Our ref: DOC22/67611  
Senders ref: SSD-17899480

**Subject: Environmental Impact Statement - Wentworthville Northside West Clinic Extension (SSD-17899480)**

-  EXISTING TREES TO BE REMOVED
30 existing trees to be removed
-  EXISTING TREES TO BE RETAINED
14 existing trees to be retained

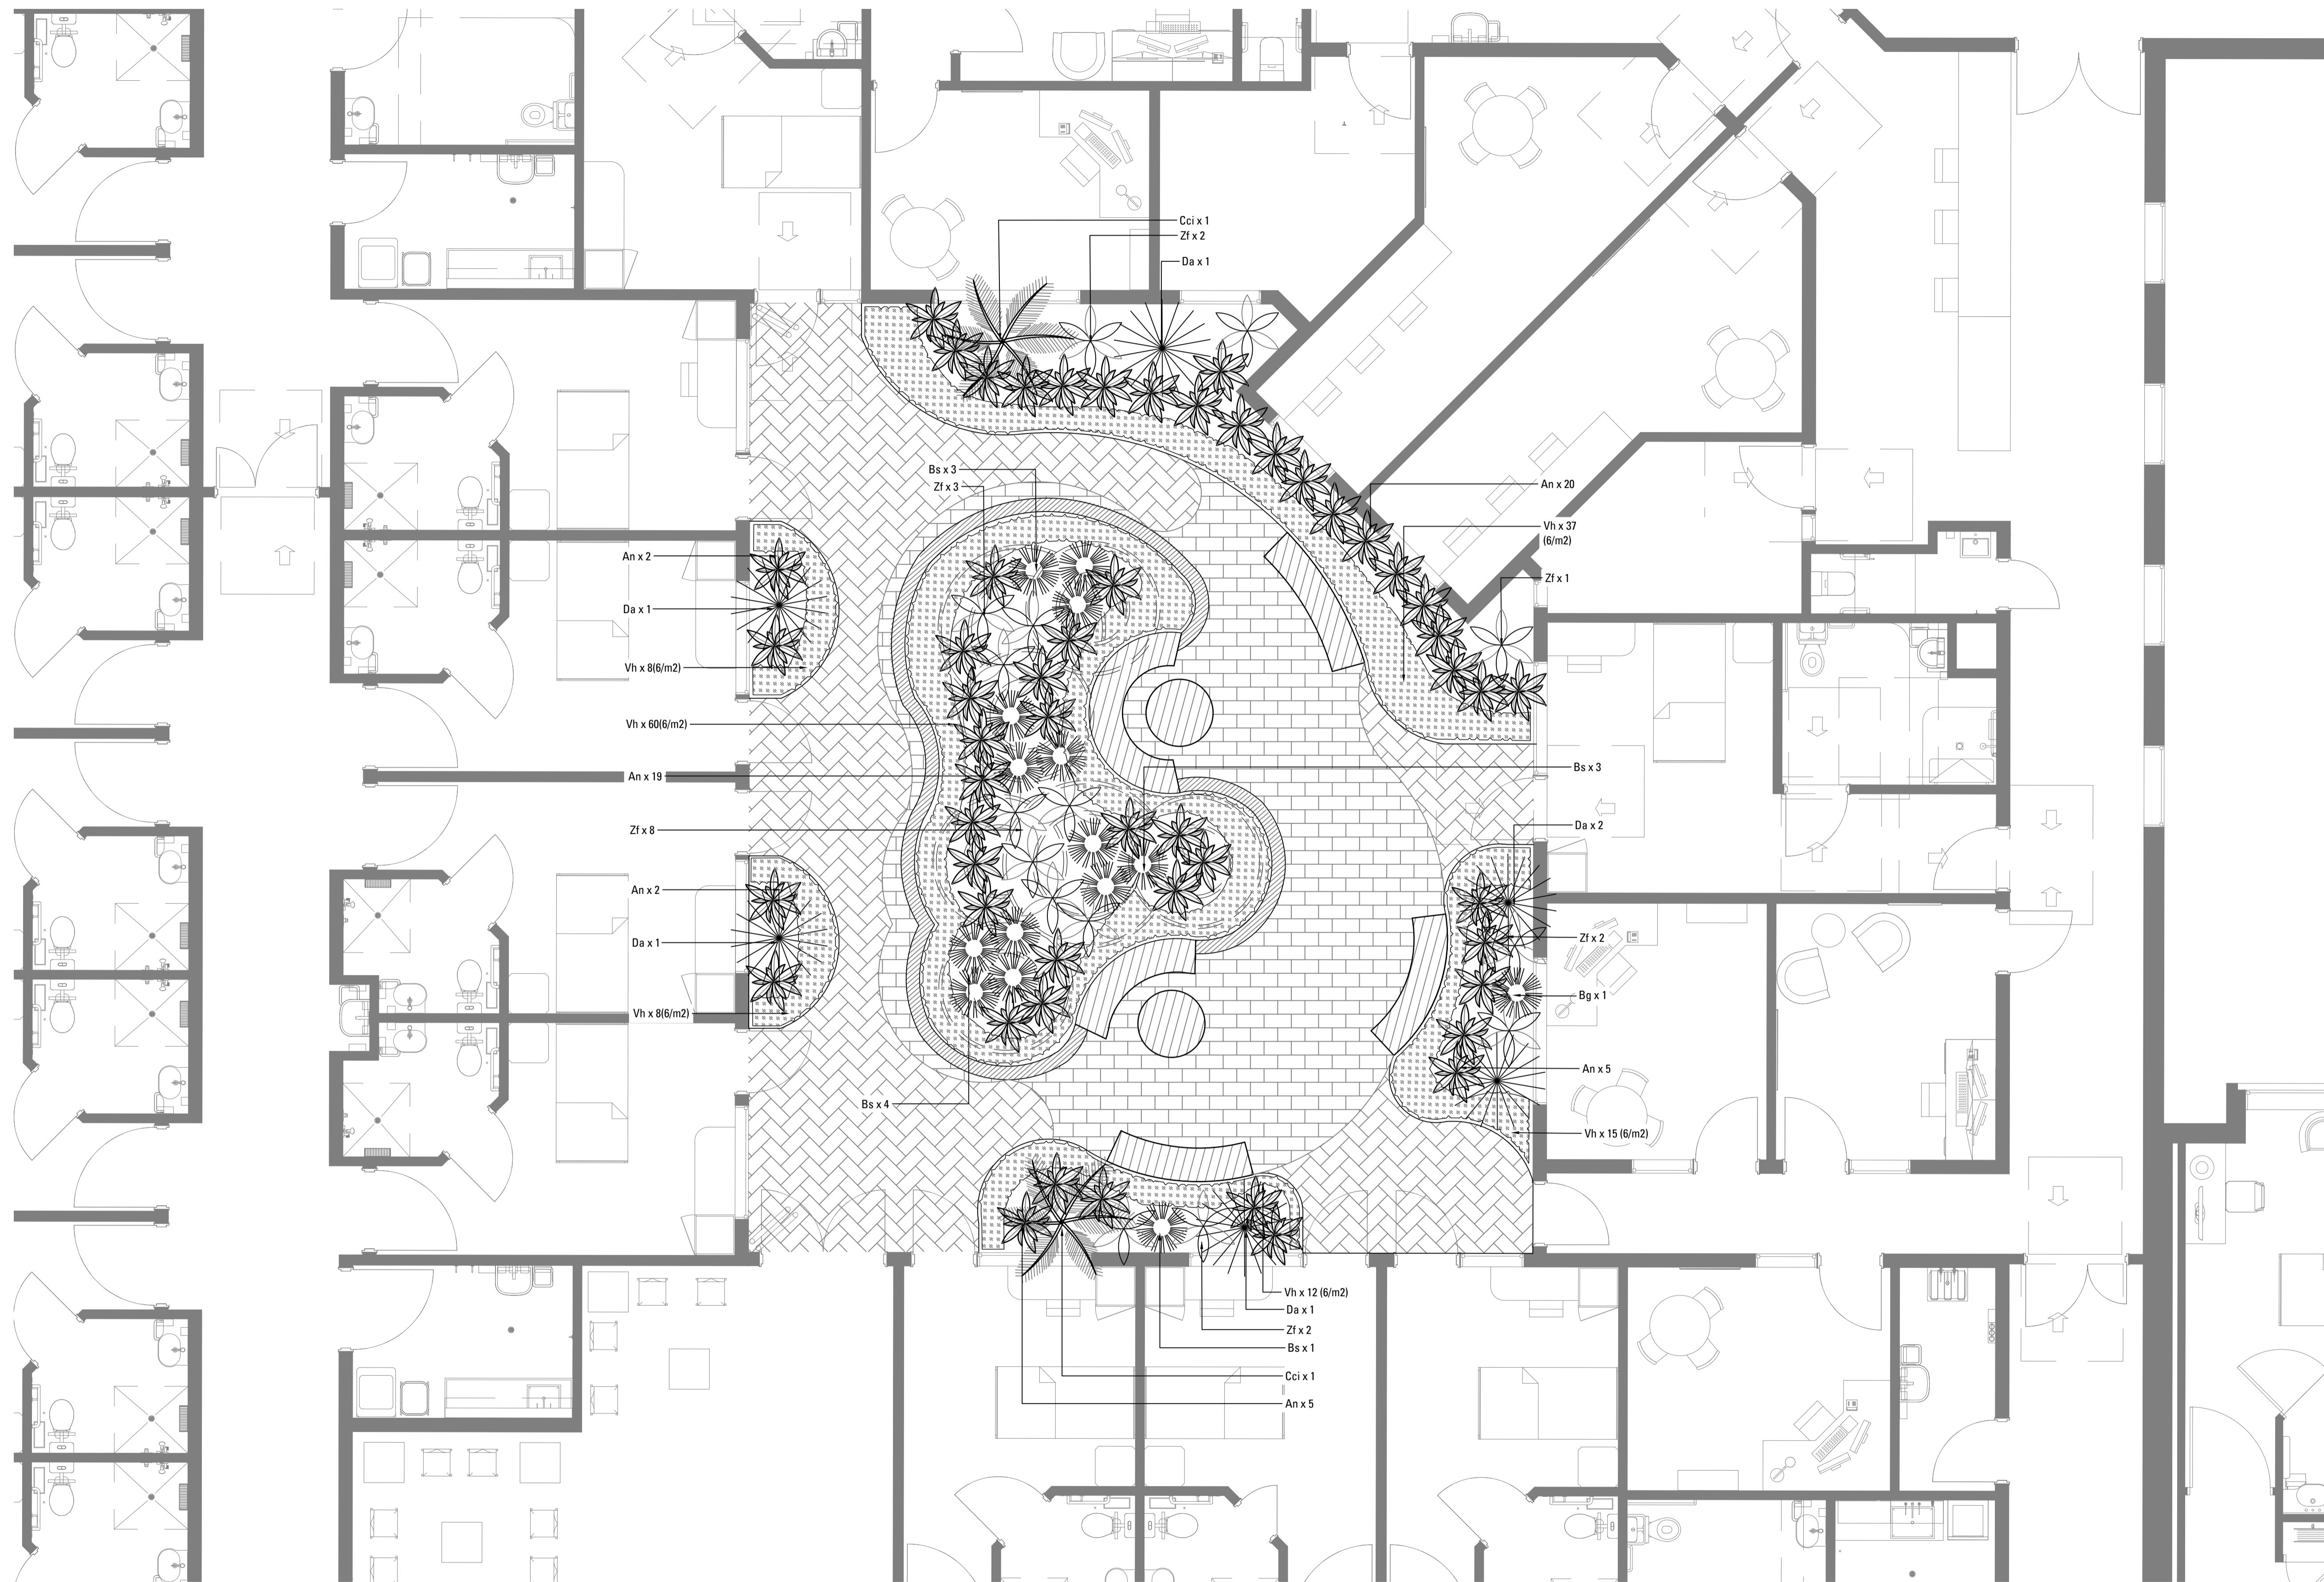
In addition to the biodiversity impacts considered in the BDAR, the impacts to individual trees are further considered in the Arboricultural Impact Assessment prepared by Bird Tree Consulting (the arborist report). The arborist report identifies 30 trees requiring removal which is consistent with the assessment of impacts in the BDAR. However, the following additional impacts are identified and need to be further addressed:

- Tree 47, *Eucalyptus microcorys*, is located within an adjoining property and is subject to major tree protection zone (TPZ) encroachment. The arborist report recommends root mapping be undertaken to determine the extent of impacts to existing roots from this tree within the subject site. The outcome of this investigation will determine if the tree can remain viable under the current proposal or if amendments are required to the construction footprint or landscape design to avoid any unsustainable impacts.

- Trees 41, 48 and 49 are also subject to major encroachment into their TPZ. Further root investigations have not been recommended for these trees. Australia Standards for the Protection of trees on development sites (AS4970:2009) states that the project arborist must demonstrate that trees with a major encroachment will remain viable. The arborist report has not provided adequate justification to demonstrate this. EES recommends further root investigations be undertaken for these trees in accordance with the recommendations of AS4970:2009.

- Tree 41 also requires canopy reduction of approximately 20%. The cumulative impact of proposed canopy reduction and TPZ incursions/root loss should be further addressed by the project arborist.

- The impacts of a proposed new substation within proximity to trees numbered 16, 17, 18, 20 and 53 does not appear to have been considered. The impacts to these trees from the substation should be addressed.

- Seven trees are proposed within the new landscape design, 3 of which are exotic, dwarf species. Given 30 trees are proposed for removal, the opportunity to incorporate additional tree planting into the landscape design should be investigated.
